Planning Officer: Mr S Davis

Planning Application Ref: WA/98/21/PL

Location: Brookview Nursery, Eastergate Lane, Walberton, BN18 0BA

Description of works: Removal of outdoor storage, including caravan and polytunnels and the erection of 7no. units comprising of 12 offices and 3 workshops, associated parking, drainage and turning spaces (resubmission following WA/58/21/PL). This site is in CIL Zone 3 (Zero Rated) as other development

Proposed Block Plan
Scale 1:500

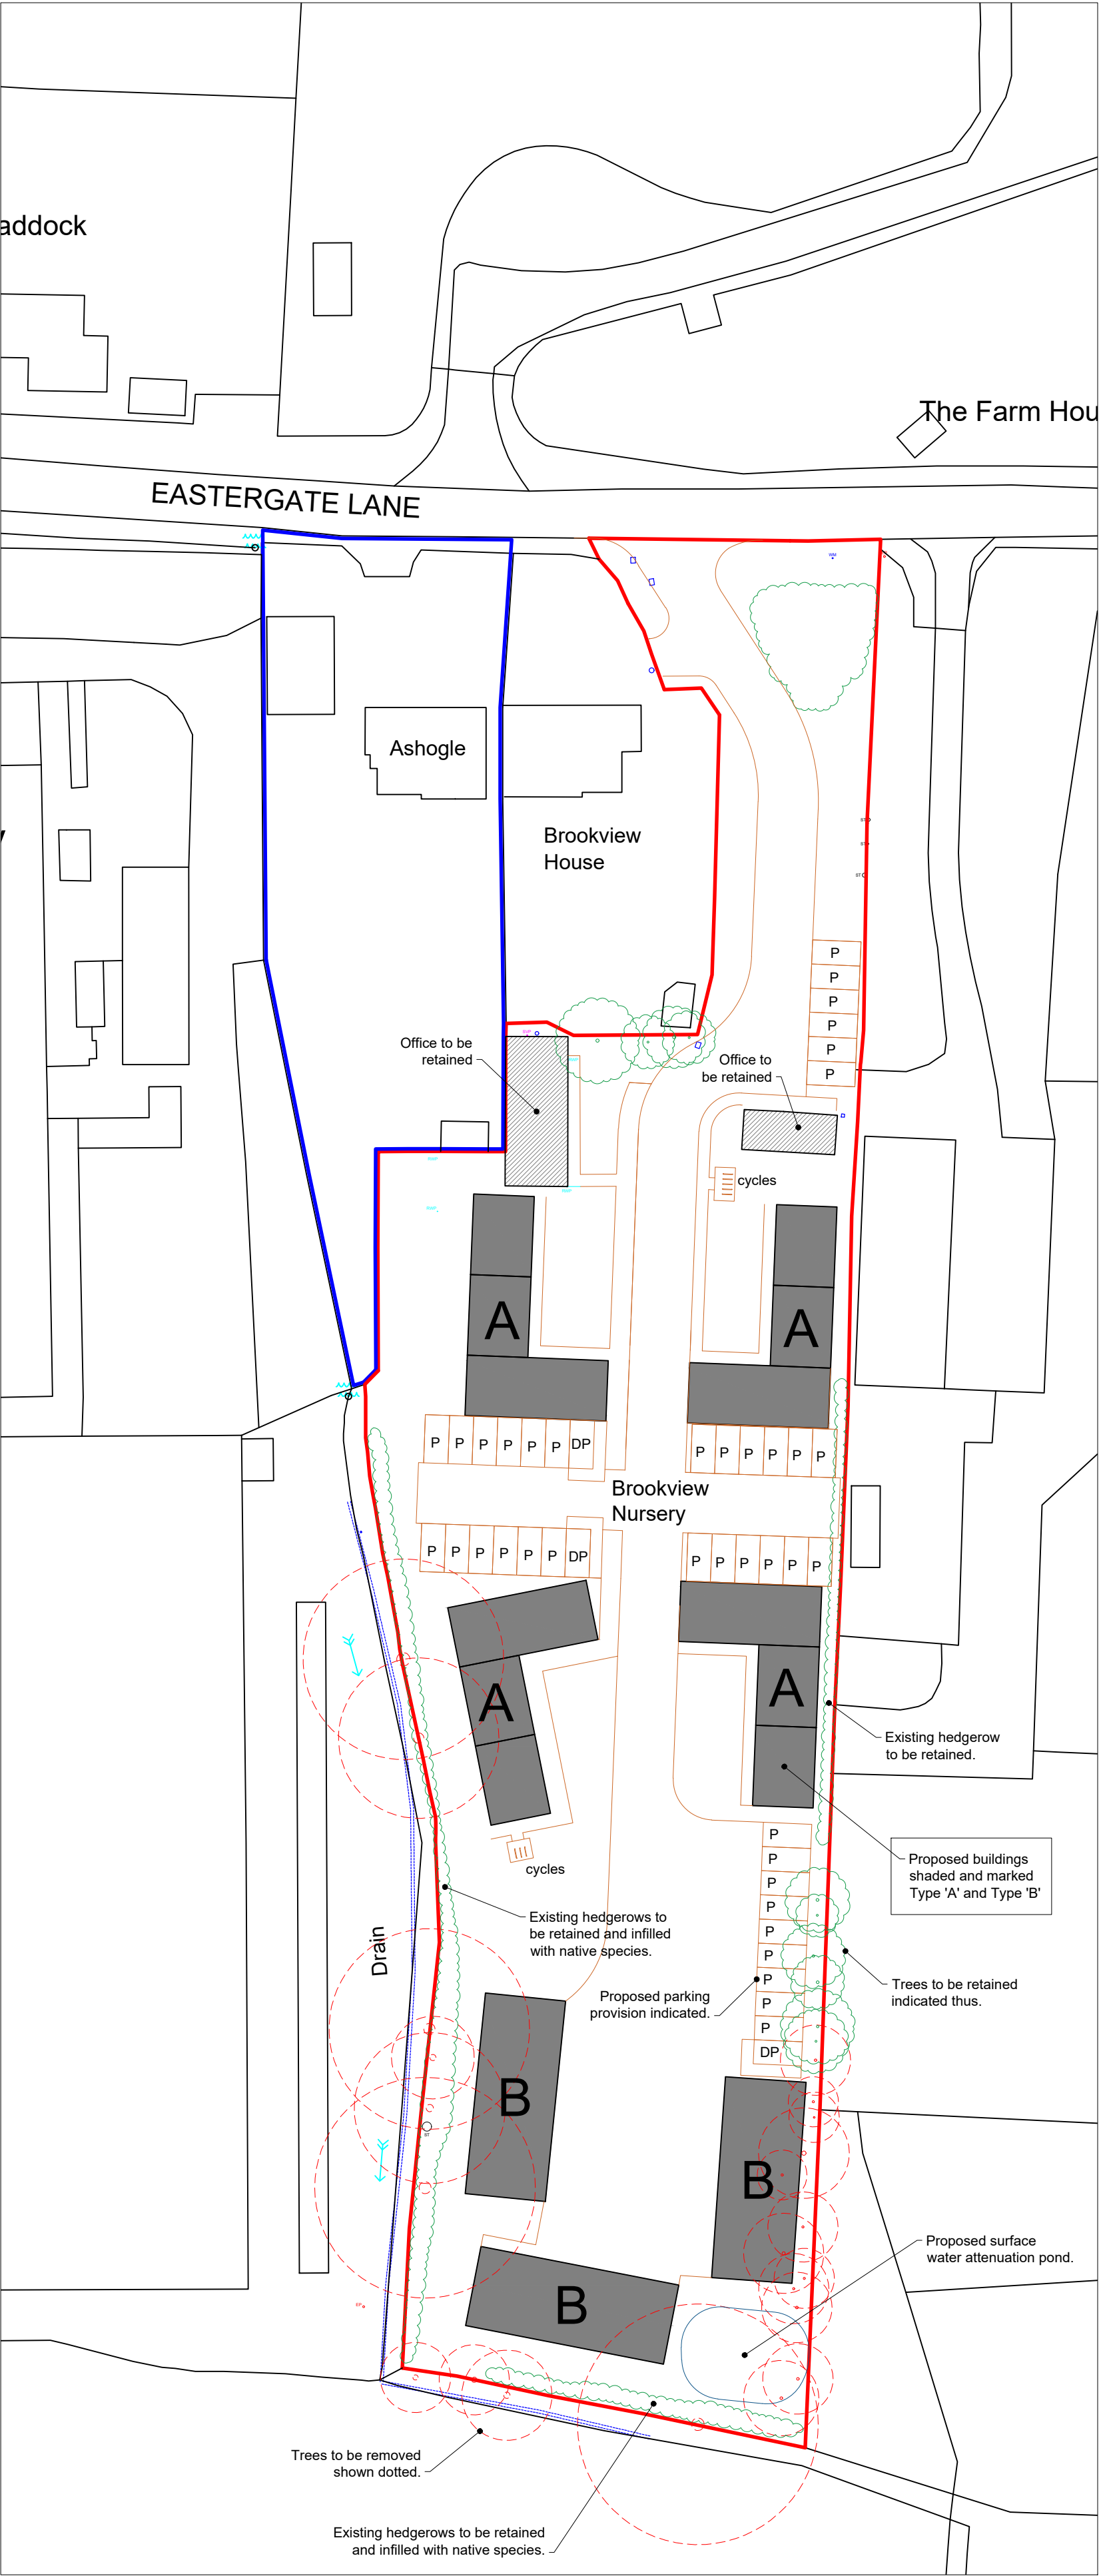
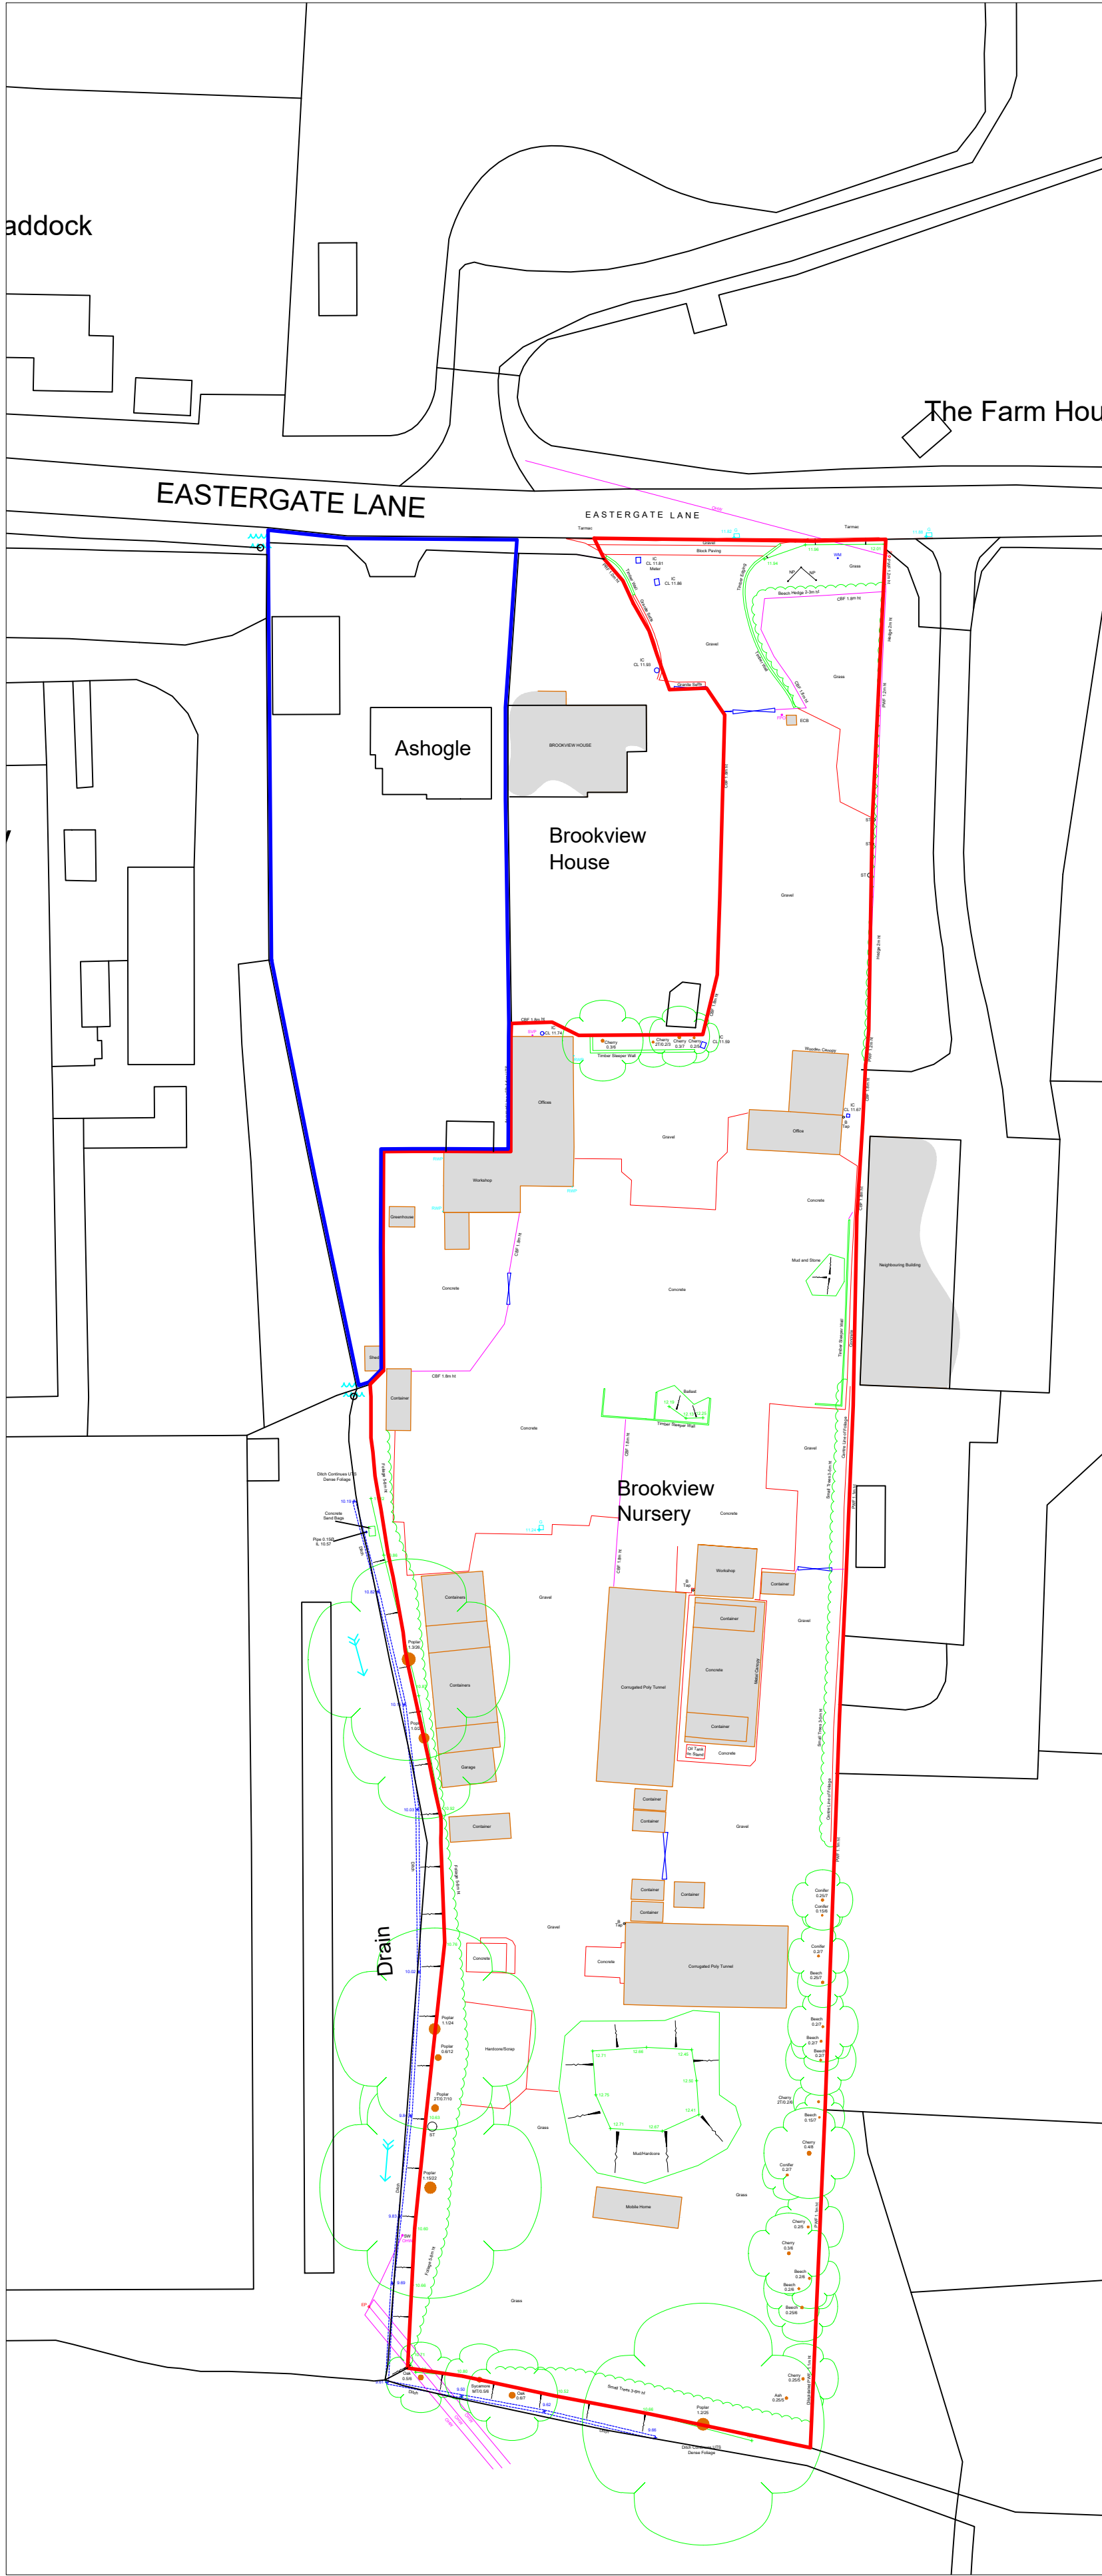
- There is an unacceptable lack of detail in the proposed layout, such that we cannot adequately assess the impact of the proposals on retained trees nor control the extent of same were this application to be approved in current form.

- The general 'principle of development' as described is achievable without undue detriment to retained trees, but it requires a more sympathetic and less intrusive layout. I suggest the applicant be encouraged to draw buildings away from South and West boundaries, exploiting the centre of the site so that RPAs are left largely inviolate.

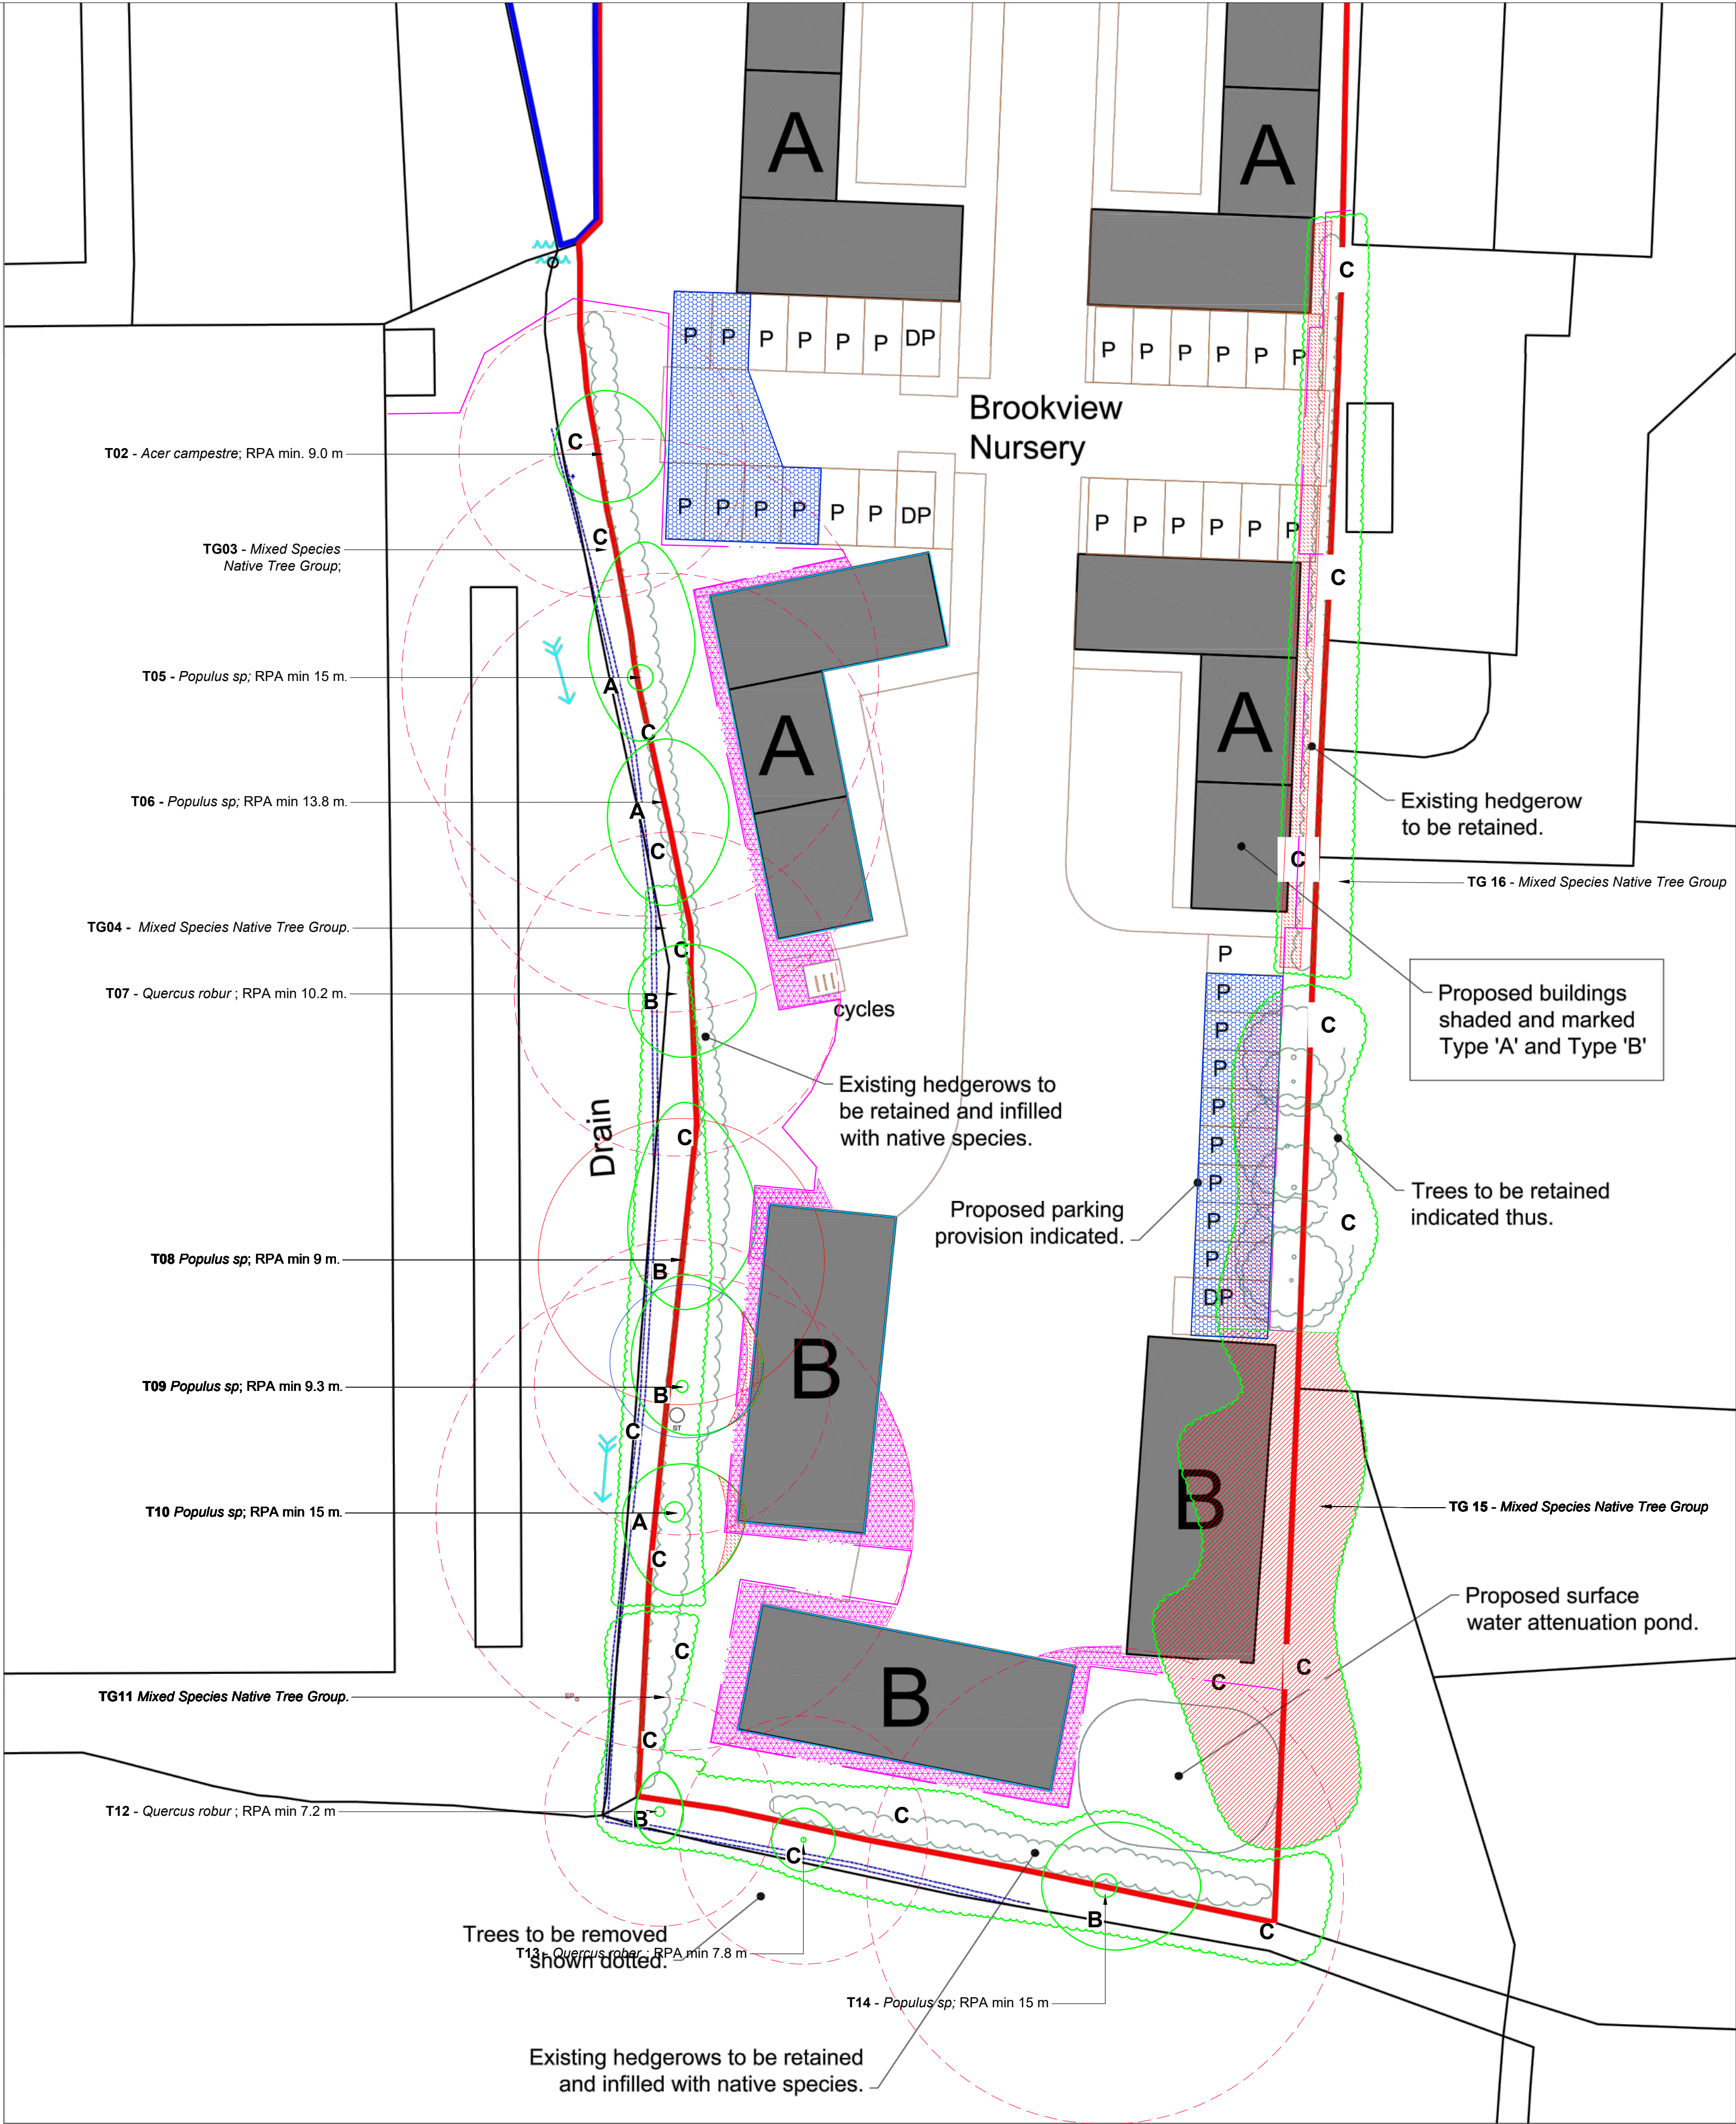
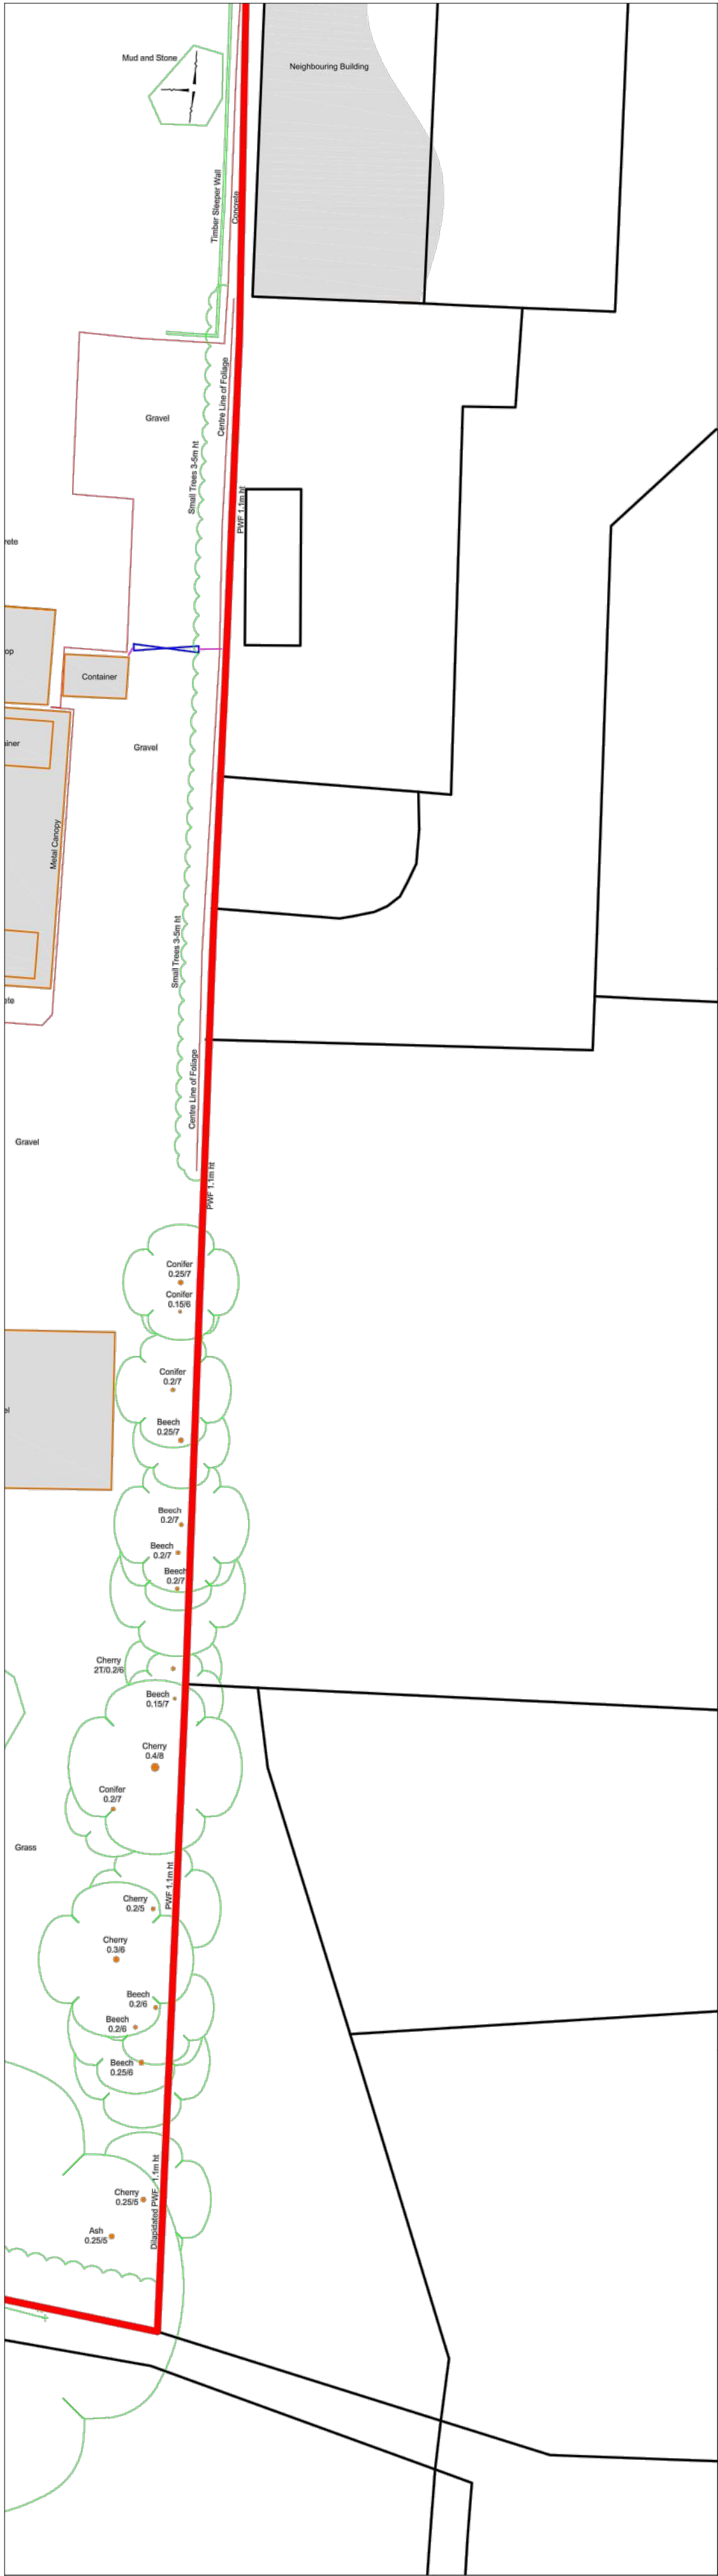
- There is a notable discrepancy between the submitted TRPP3 and report-based intentions for T13 oak. The plan is annotated with an instruction to remove, yet there is no statement to that effect within the AIA/MS.

- The introduction of a surface water attenuation pond within the RPA of T14 is an unacceptable intrusion on the tree and could jeopardise long-term integrity of that SUDS feature.
